Office of
Environment
& Heritage

RE: Exhibition of State Significant Development application for Bringelly Road Business Hub, Leppington, Liverpool (within the Western Sydney Parklands) (SSD 6324)

Bringelly Road Business Hub

Heritage Division, Office of Environment and Heritage comments

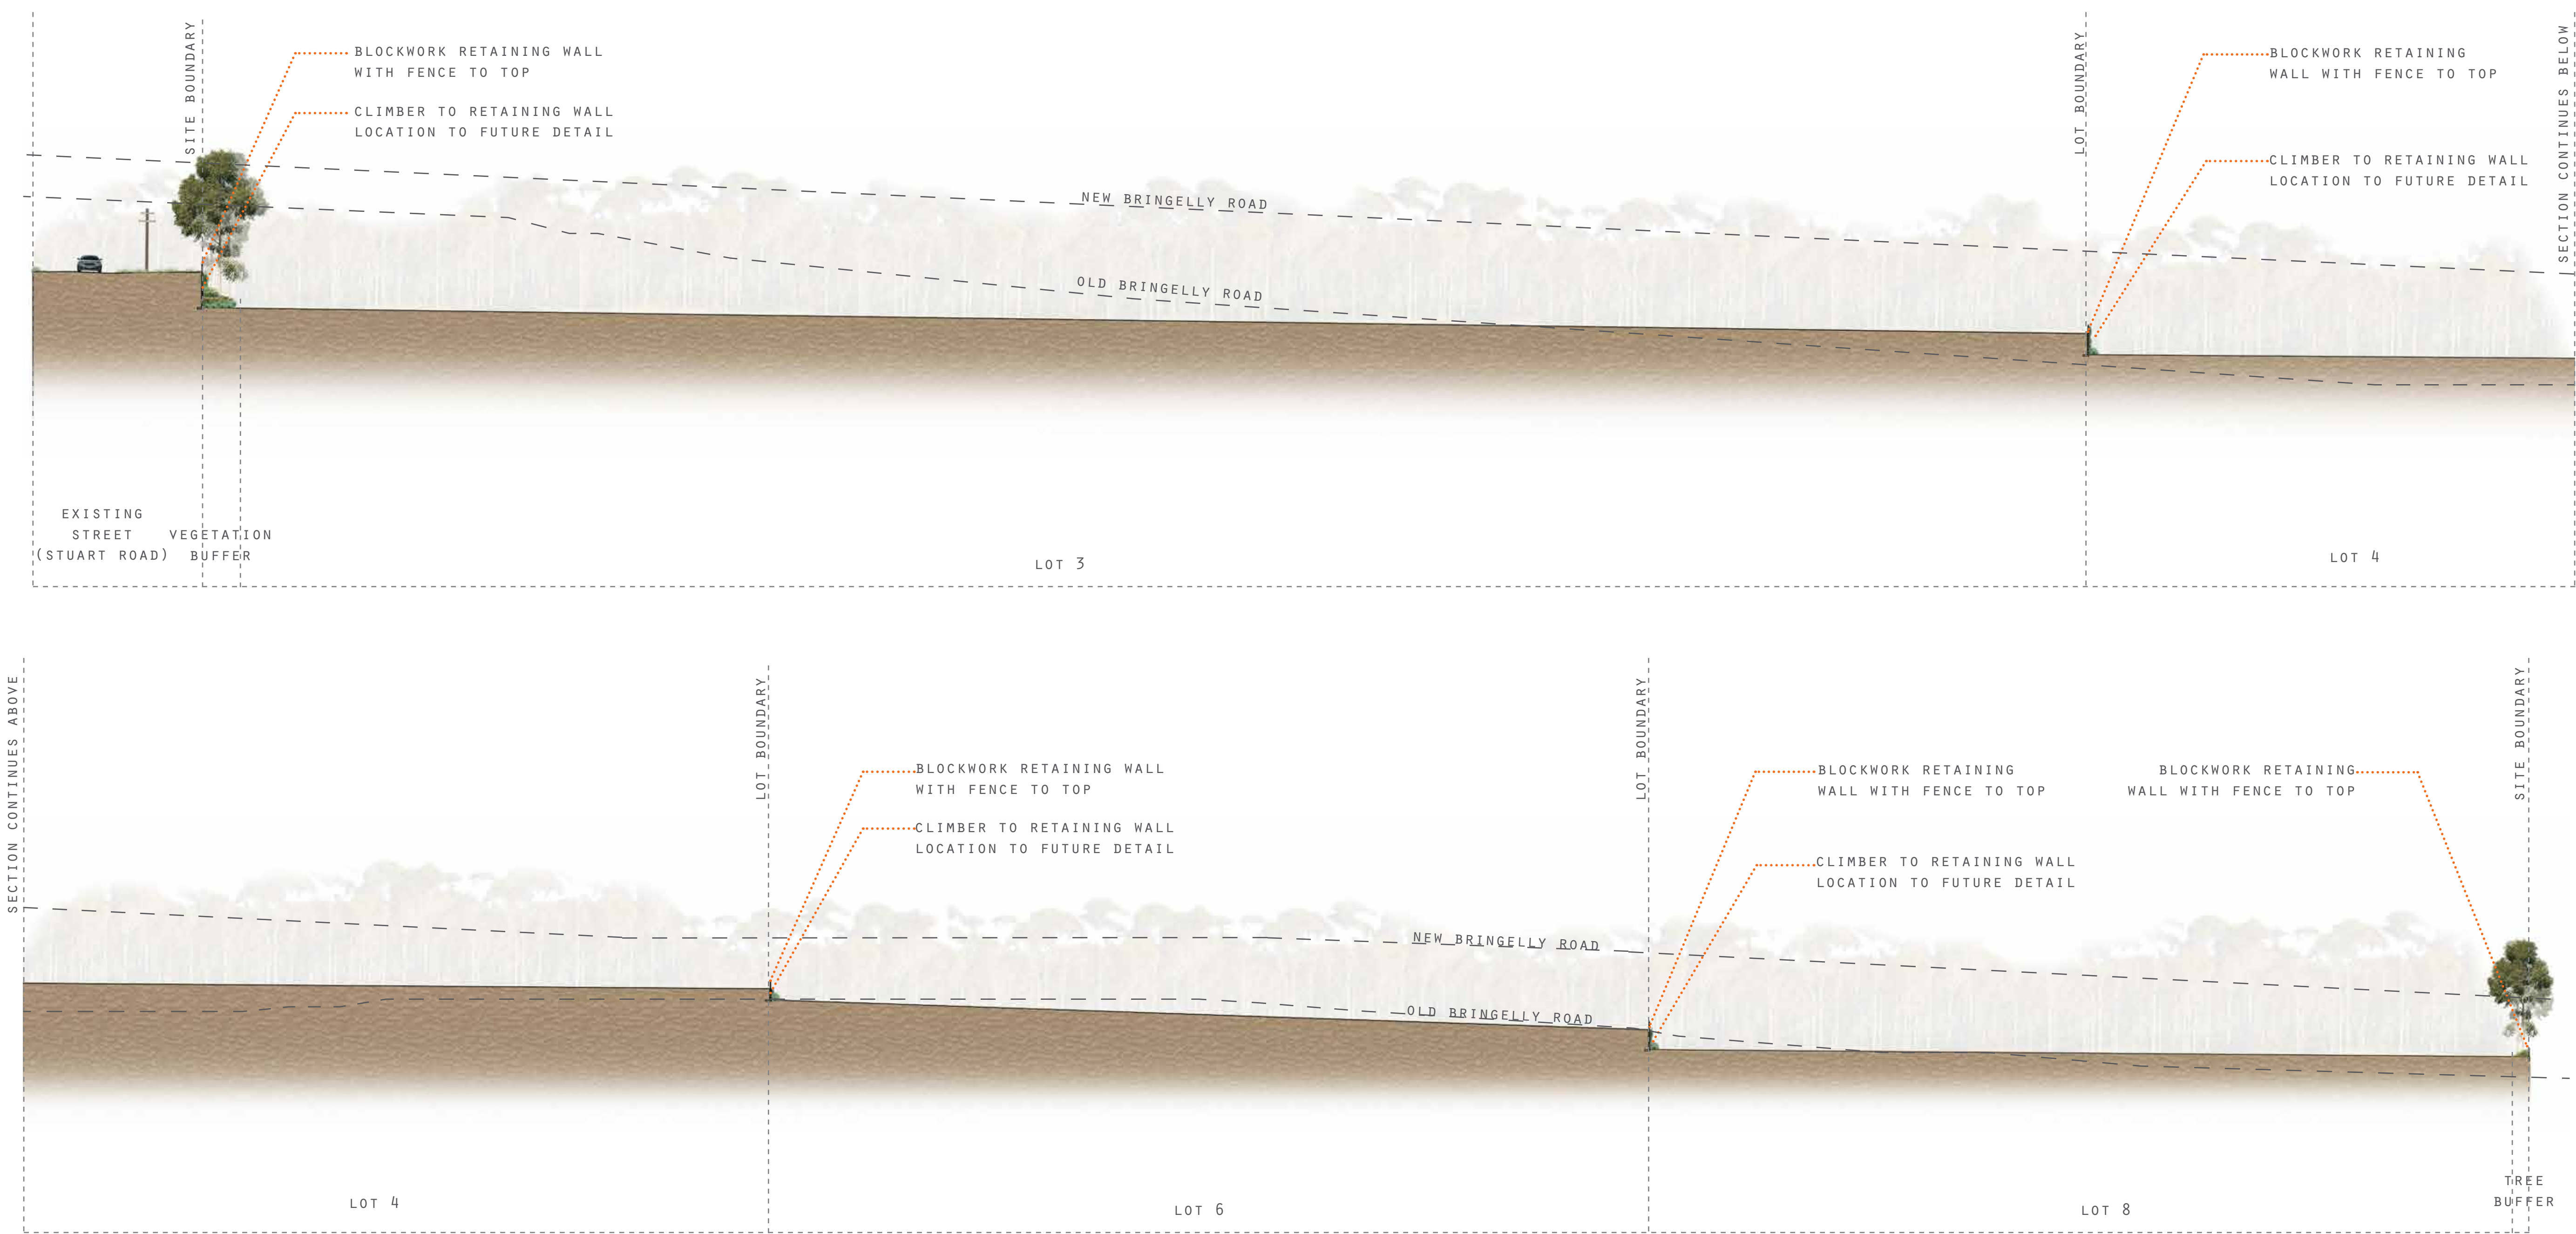
More land along the subject site's north-eastern edge could be planted with appropriate native vegetation at the north, rear, of Lot 6 and Lot 8 to supplement adjacent riparian corridor buffer zone. Such planting would not unduly hinder operations of either lots, both of which face south for their access and functioning.
